# CITY OF ALBUQUERQUE

**Re: Horizon Blvd NE  
8830 Horizon Blvd NE  
Request for Certificate of Occupancy  
Transportation Development Final Inspection  
Engineer's/Architect's Stamp dated 7-26-19 (C17D127)  
Certification dated 3-23-20**

Based upon the information provided in your submittal received 5-4-20, Transportation Development cannot approve the release of Certificate of Occupancy for the above referenced project.

Traffic Circulation Layout
TCL001

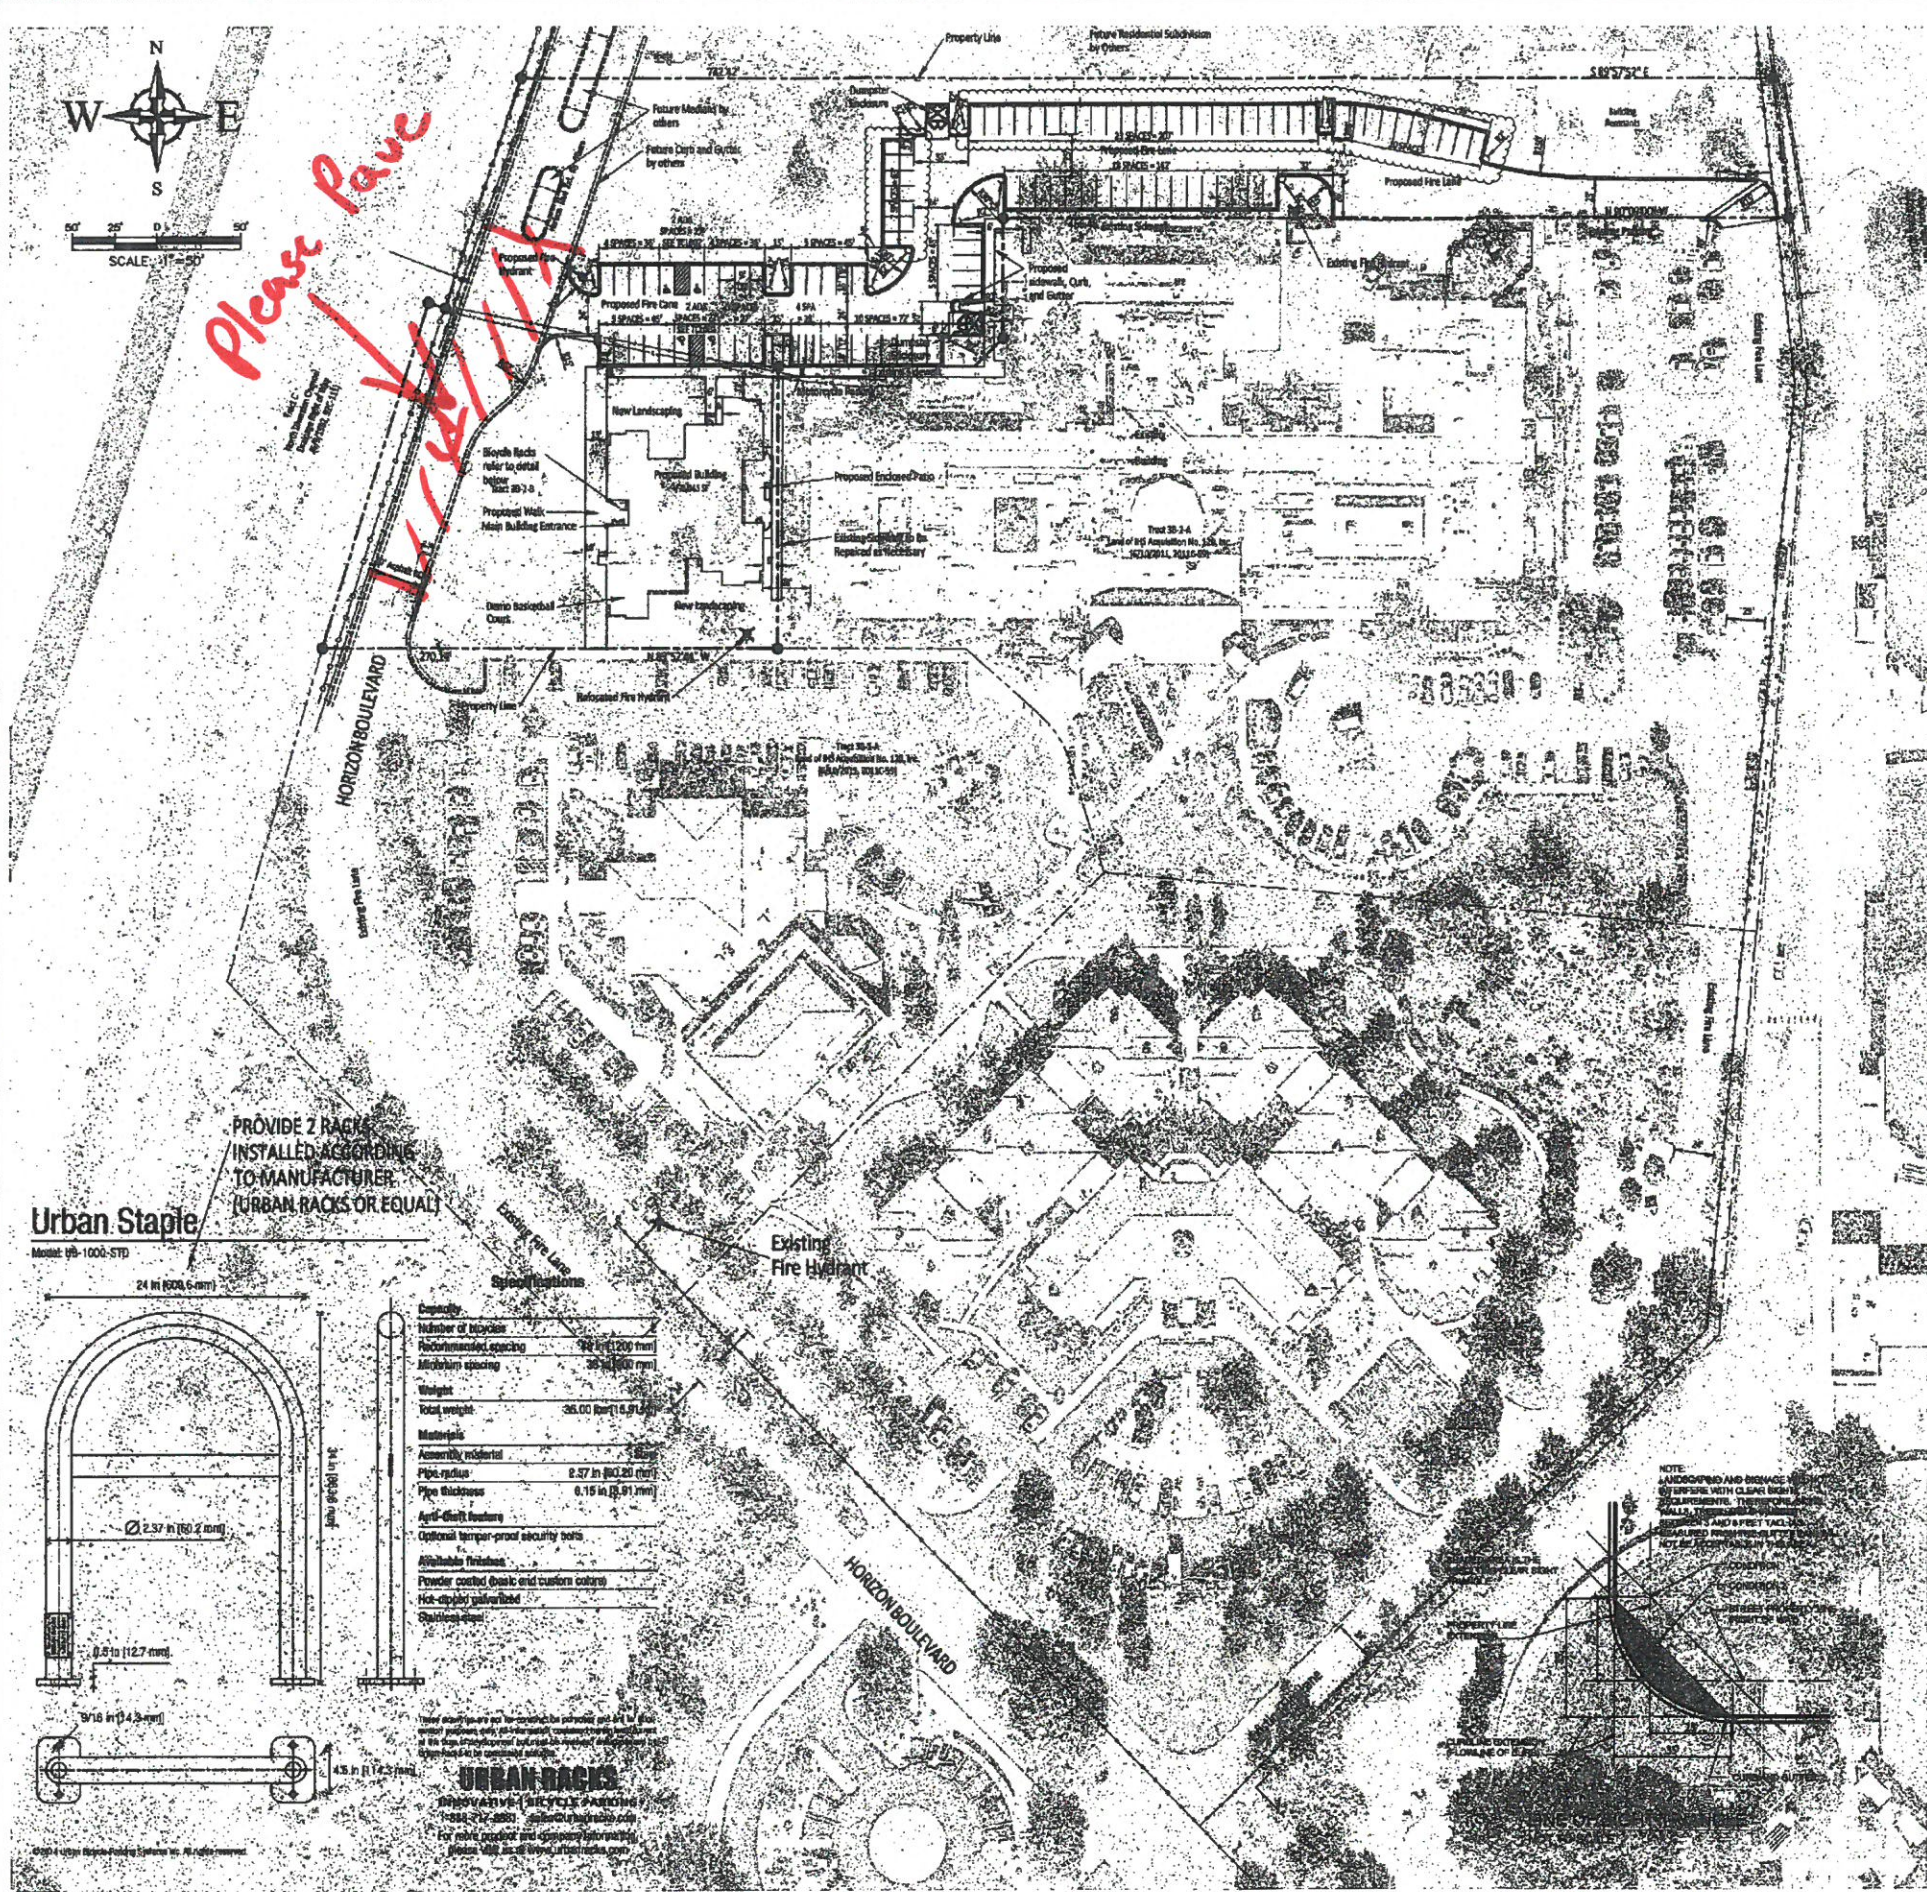
- Please complete asphalt paving on Horizon.

1. The approved and stamped TCL with changes drawn in red.
2. Transportation Certification letter on either the plan or applicants letterhead.
3. A Drainage Transportation Information Sheet (DTIS)
4. Send an electronic copy of your submittal to [PLNDRS@cabq.gov](mailto:PLNDRS@cabq.gov).
5. The \$75 re-submittal fee for log in and evaluation by Transportation.
